**RE: Headrick Garage and Pool Addition (CAO19-014) - Applicant's Response to 9.17.19 City Review Comments**

Wetland Resources, Inc. (WRI) recently received a letter from City of Mercer Island planning staff (date: September 17, 2019, subject line: Review Comments for File No. CAO19-014 - Headrick Garage and Pool Addition 8822 SE 62<sup>nd</sup> Street, Mercer Island, WA 98040; King County Tax Parcel #865050-0040). The letter requests additional information prior to finalizing the application. The following narrative re-states all comments made by City staff as italicized, indented text, which are immediately followed by the applicant's response as justified, normal text. This memo is intended to provide adequate information for City staff to complete review of the Critical Areas Determination for this project.

Figure 2: Existing Site Conditions and Channel Measurement Location

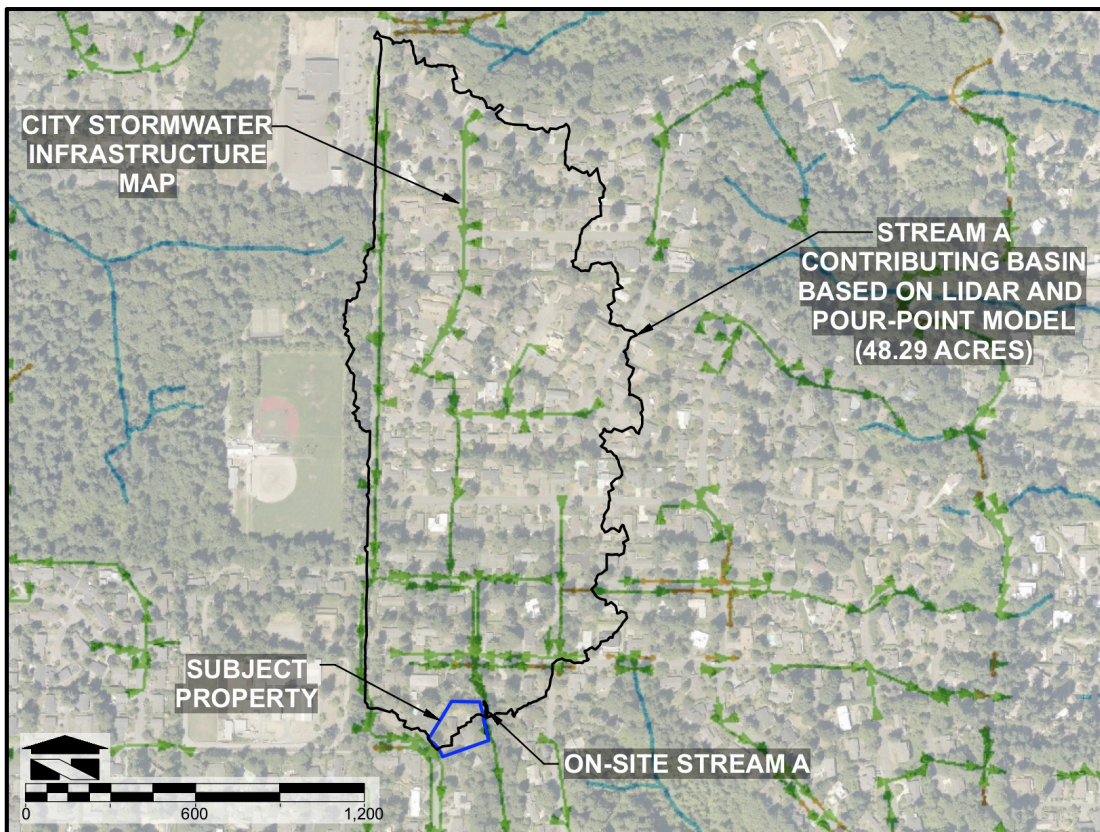
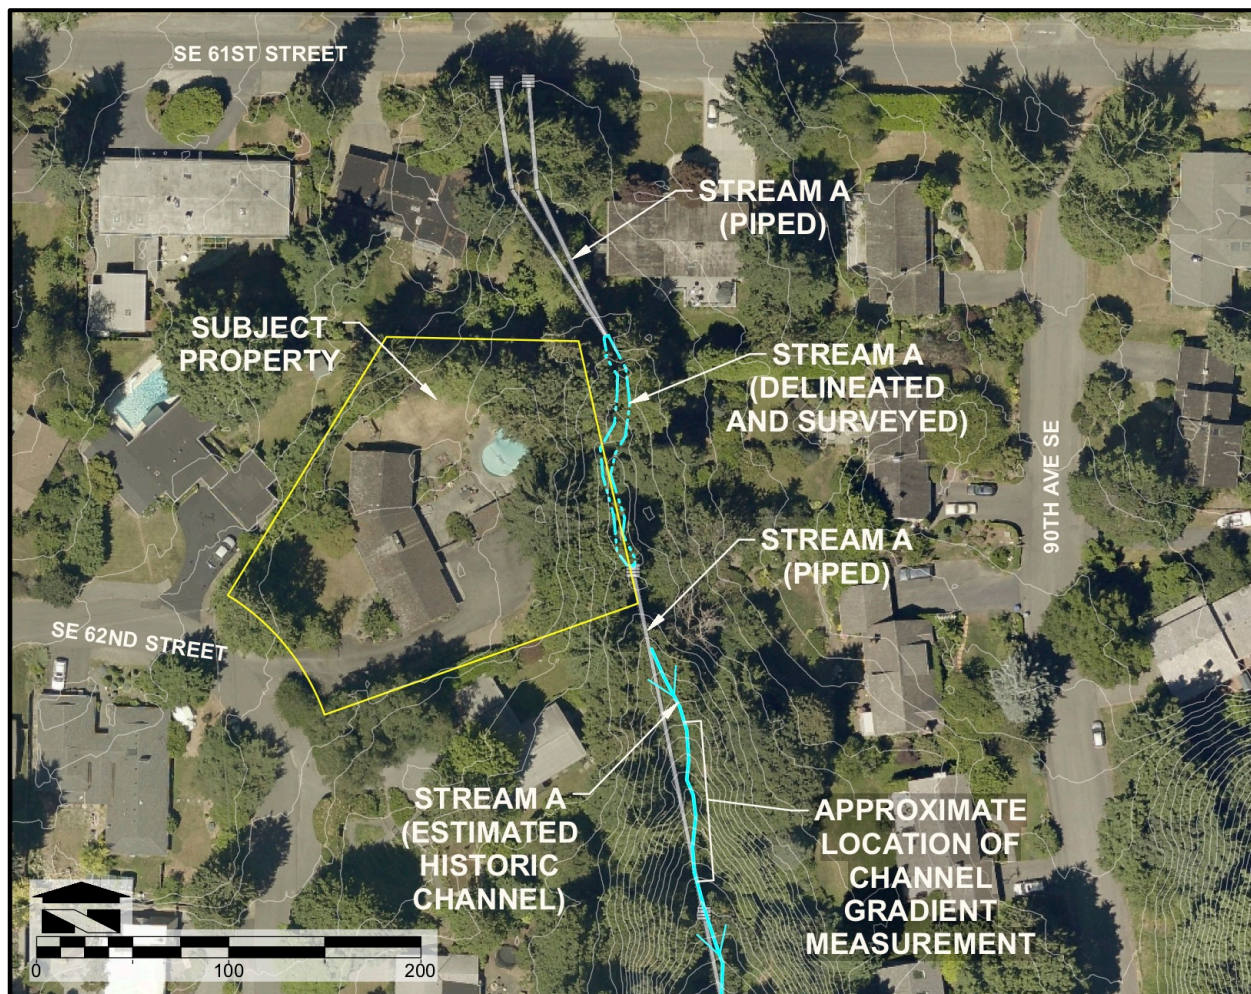
*1. The City agrees that Stream A is a seasonal stream. There are no records of fish use in Stream A, therefore WRI contends that this watercourse should be classified as a Type 3 stream per MICC 19.07.070. The City does not fully agree with the Type 3, non-fish bearing stream classification of Stream A based upon observations during our site visit and the rules of WAC 222-16-031. The WAC rules state that fish use is presumed for waters with 2 feet or greater bankfull width and 16 percent or less gradient. The stream gradient is not provided in the Critical Area Study. More information regarding the stream gradient is needed to determine fish use and stream type classification.*

**Applicant's response:** Based on observed steep topography using publicly available LIDAR information, the applicant took physical measurements in an area immediately downstream of the subject property. Stream gradient was determined to be 21°, which precludes fish use according to the WAC. A formal memo was drafted to support the applicant's findings (date: 10.29.19, title: RE: Headrick Garage and Pool Addition Watercourse Classification Memo - CAO19-014). This memo is provided as an enclosure to this review comment response letter.

Critical Area Study Map
Headrick Garage and Pool Addition
8822 SE 62nd St
 Proposed Development Sheet 2/3
 Greg & Jennifer Headrick Project Number: 18303
 8822 SE 62nd St Drawn by: NP
 Mercer Island, WA 98040 Rev. 1: 10/25/2019

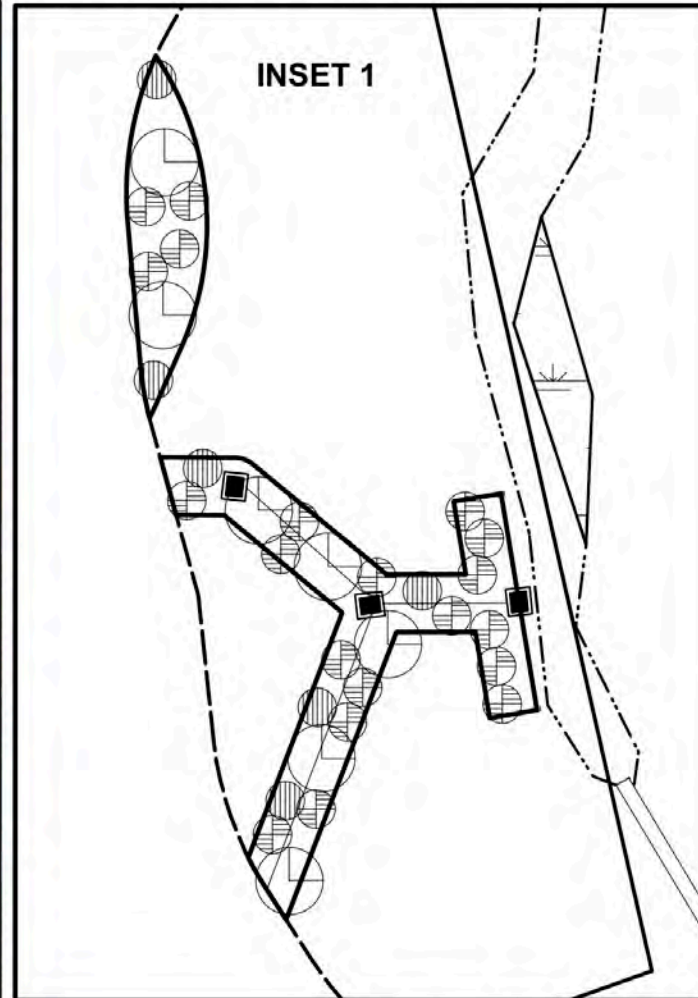
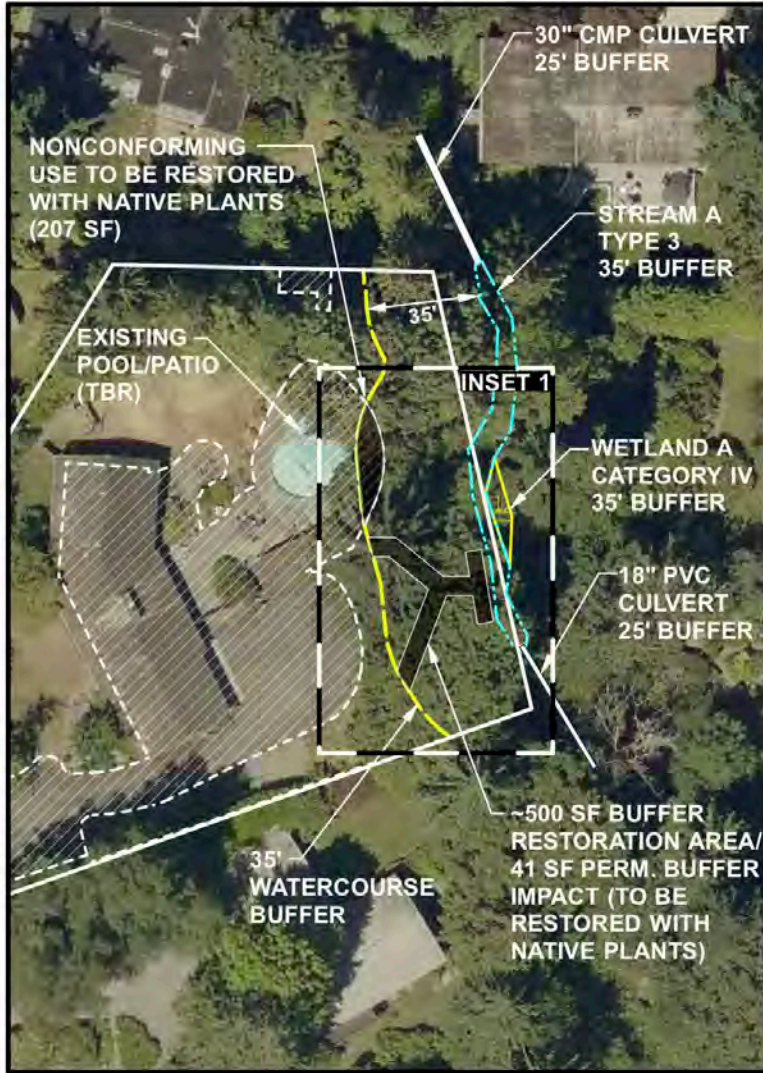
*2. Please revise the Critical Area Study to address permanent and temporary impacts to the buffer or Stream A resulting from proposed stormwater infrastructure construction and to include mitigation for these impacts. Consider revising the plans to avoid direct impacts to Stream A from stormwater infrastructure construction.*

**Applicant's response:** Temporary and permanent impacts are addressed in a revised Critical Area Study (date: 10.25.19, title: Critical Area Study for Headrick Garage and Pool Addition - 8822 SE 62<sup>nd</sup> St). The plan has been revised to avoid directly impacting Stream A. Impacts and mitigation are specifically discussed on the following pages of the report, which is included as an enclosure to this letter: Page iv (Executive Summary), Page 2 (Section 1.2 Project Description), Page 3 (Section 1.4 Critical Area Impacts and Mitigation), and Pages 10-17 (Section 4.0 Buffer Restoration Plan).
